The Planning Inspectorate

12 July 2023

Application by Equinor New Energy Limited for an Order Granting Development Consent for the Sheringham Shoal Offshore Wind Farm Extension Project and Dudgeon Offshore Wind Farm Extension Project

Request for Further Information

Figure 4: White-Clawed Crayfish Survey Results Map (Unnamed Tributary of the River Yare)

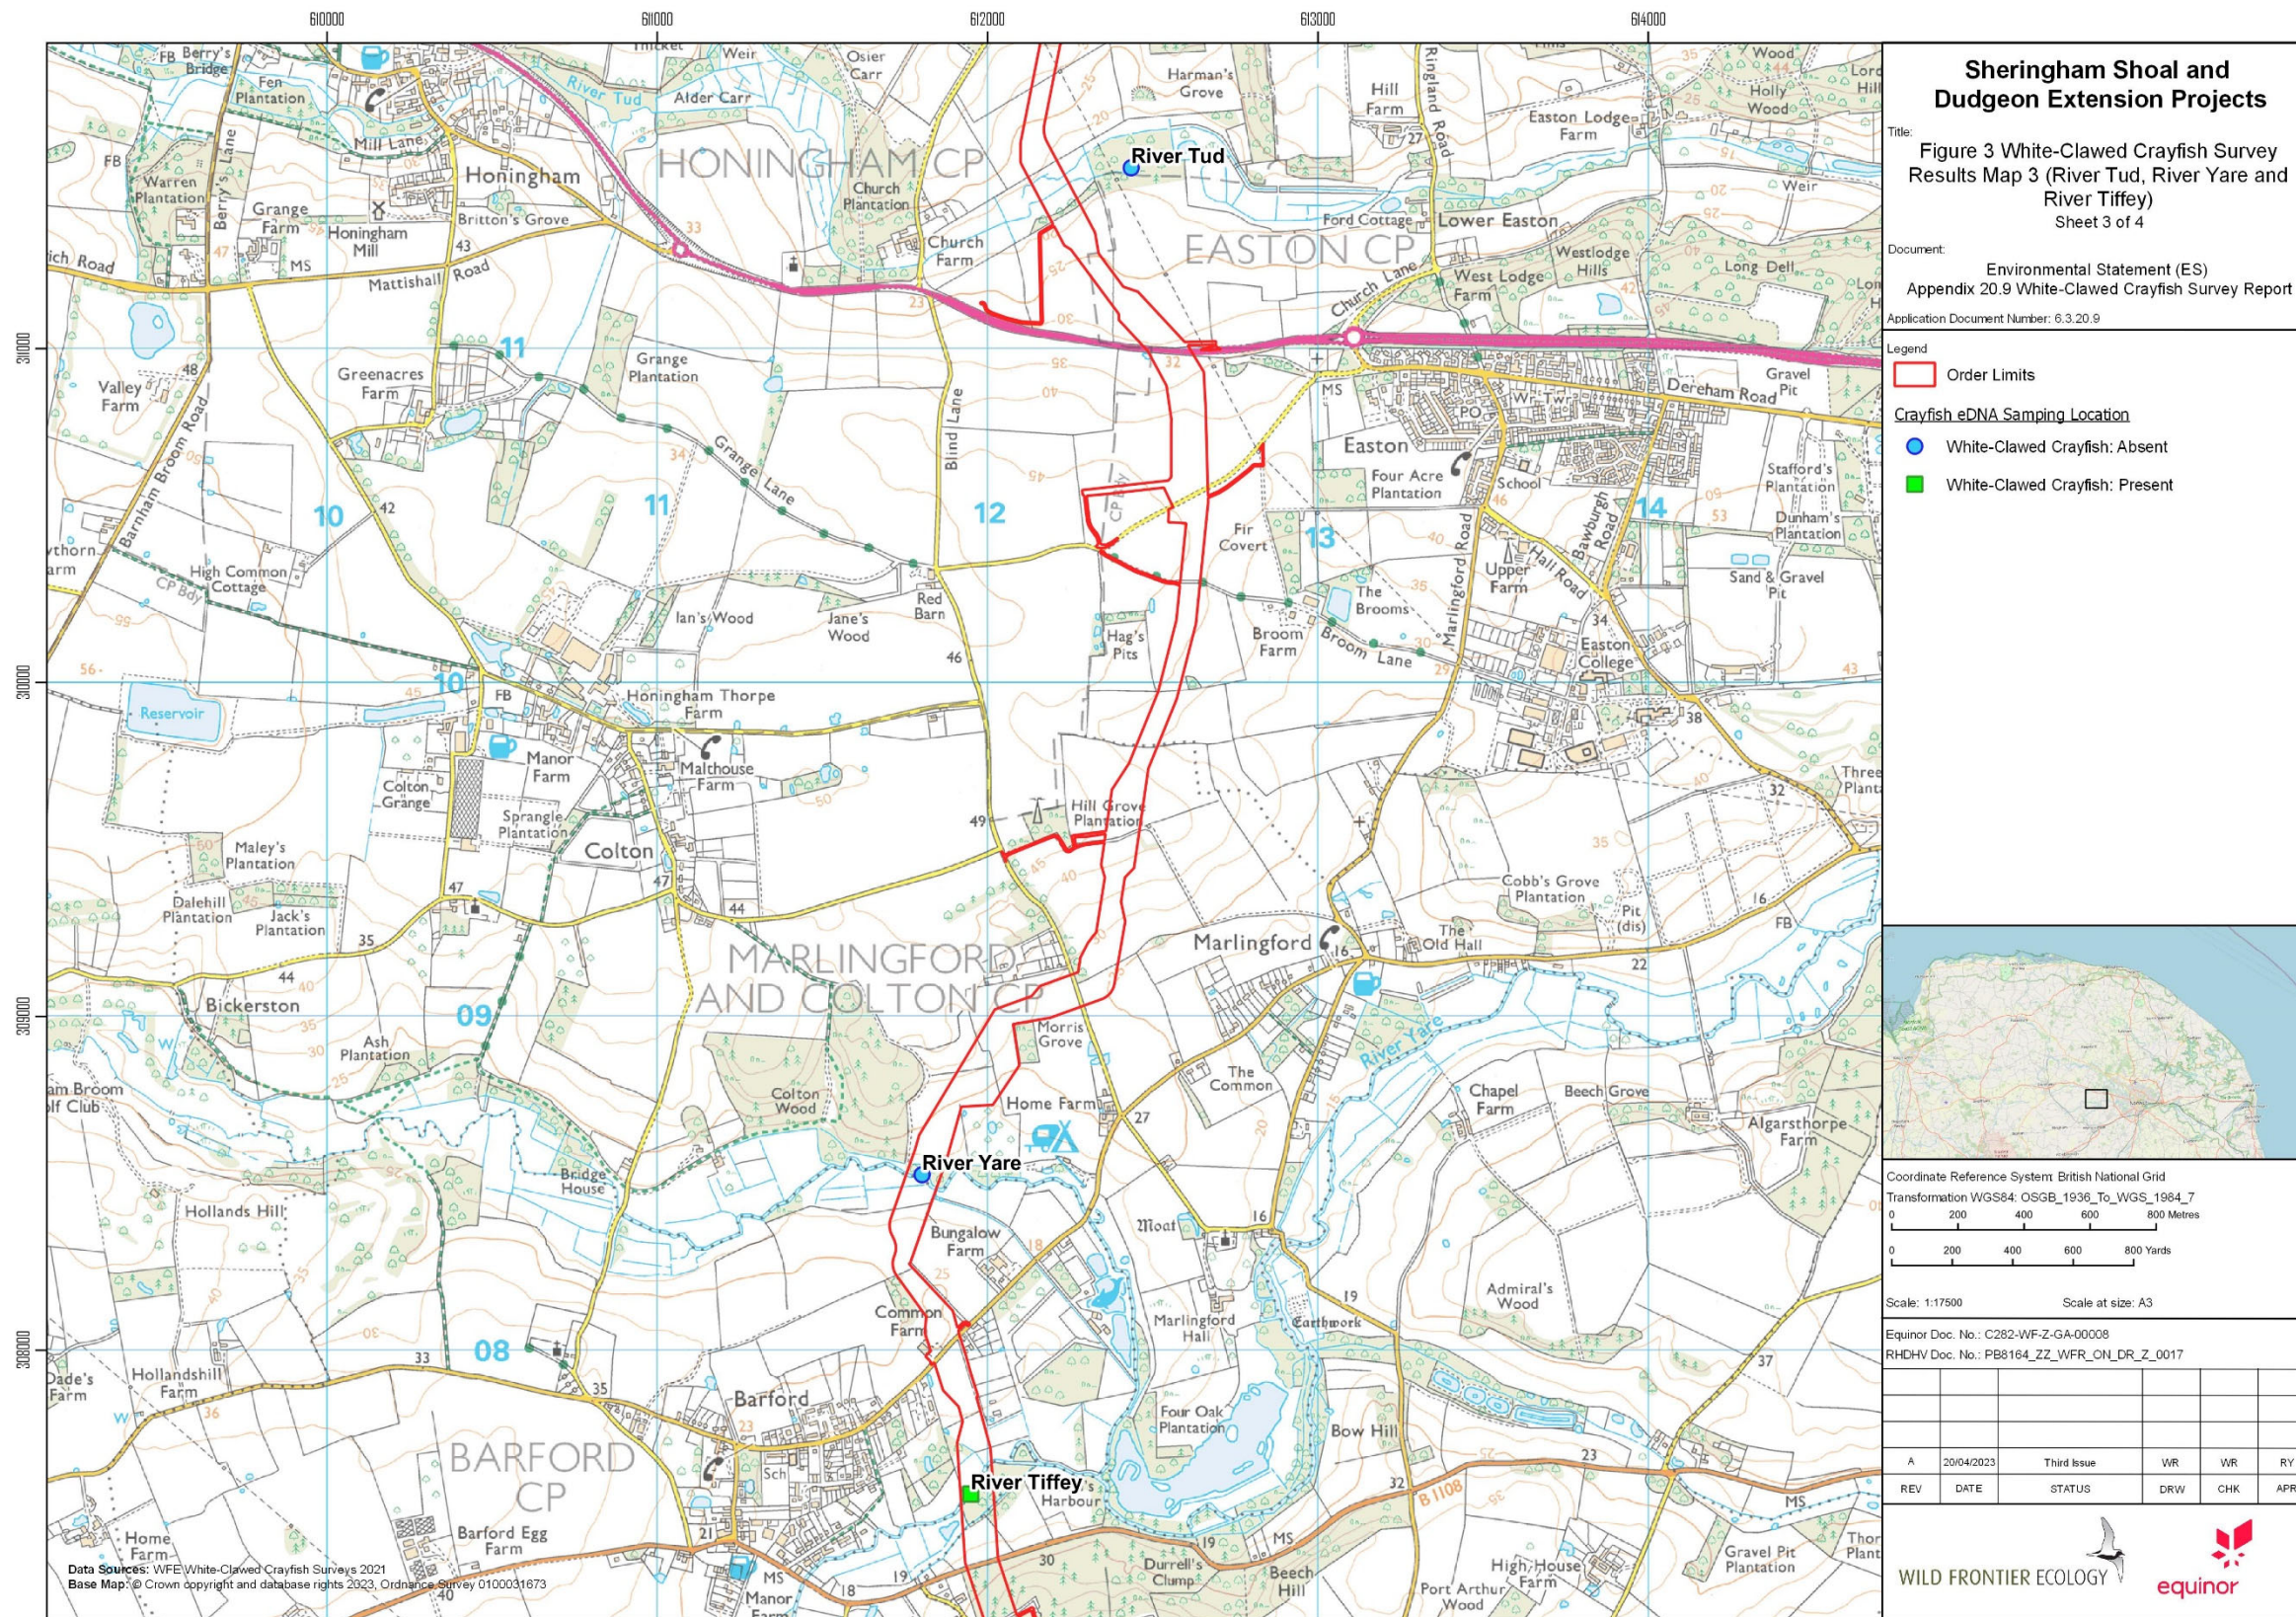
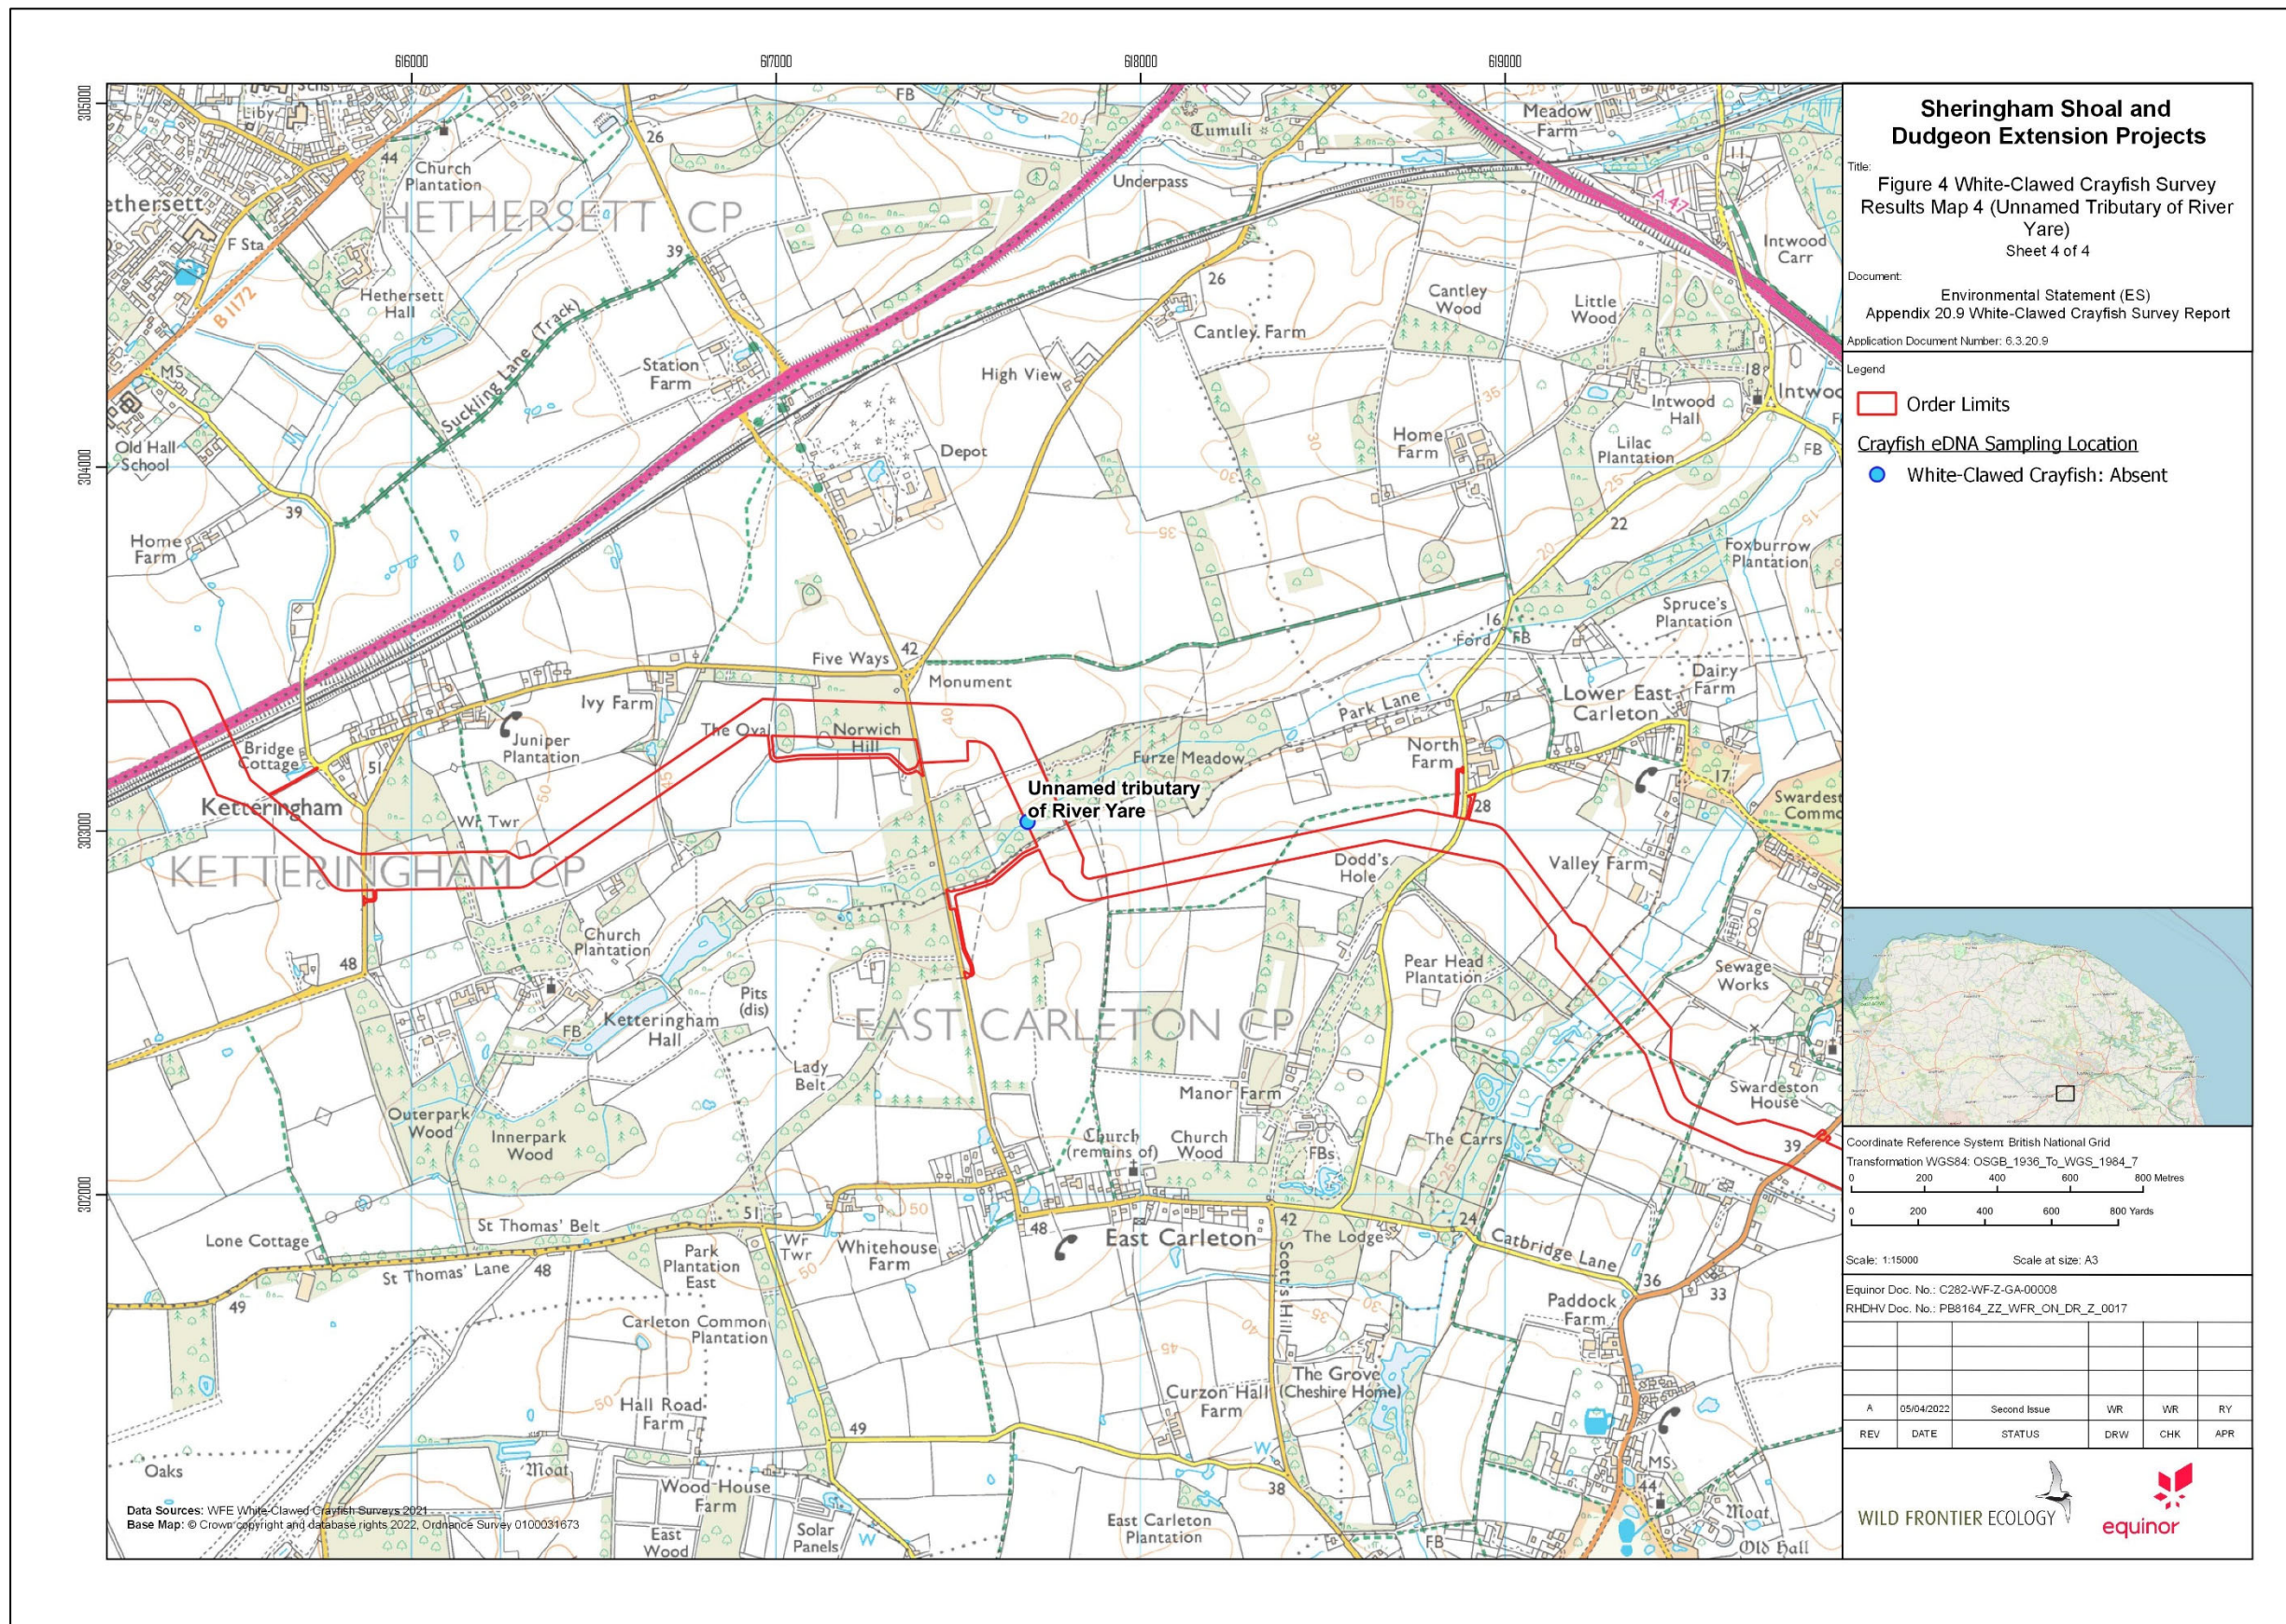
Respondent	Question
<p>Applicant</p> <p>Natural England</p>	<p>River Wensum Special Area of Conservation (SAC)</p> <p>a) Further to responses received to questions raised by the ExA from NE [REP5-094, Q3.12.2.3] and the Applicant [REP6-013, Q3.12.2.3], provide without prejudice wording for a Requirement within the dDCO which secures mitigation that removes or reduces the risk of AEol to the white-clawed crayfish, brook lamprey and bullhead features</p>

of the River Wensum SAC, before any work on the Proposed Development could commence.
Applicant Natural England	Pink Footed Goose Feature of North Norfolk Coast SPA b) Further to responses received to questions raised by the ExA from NE [REP5-094, Q3.14.1.17] and the Applicant [REP6-013, Q3.14.1.17], provide without prejudice wording for a Requirement within the dDCO which secures mitigation that removes or reduces the risk of AEoI to the pink footed goose feature of the North Norfolk Coast SPA and Ramsar site, before any work on the Proposed Development could commence.
Applicant Natural England	Wensum Woodlands c) Further to responses received to questions raised by the ExA from NE [REP5-094] and the Applicant [REP6-013, Q3.13.2] provide without prejudice wording for a requirement within the dDCO which secures mitigation that removes or reduces the risk of potential habitat loss and which ensures that the Proposed Development would not hinder any potential notification of Sites of Special Scientific Interest (SSSI) status to the Wensum Woodlands in the future. Alternatively, provide detailed reasoning which explains why such wording would not be required.
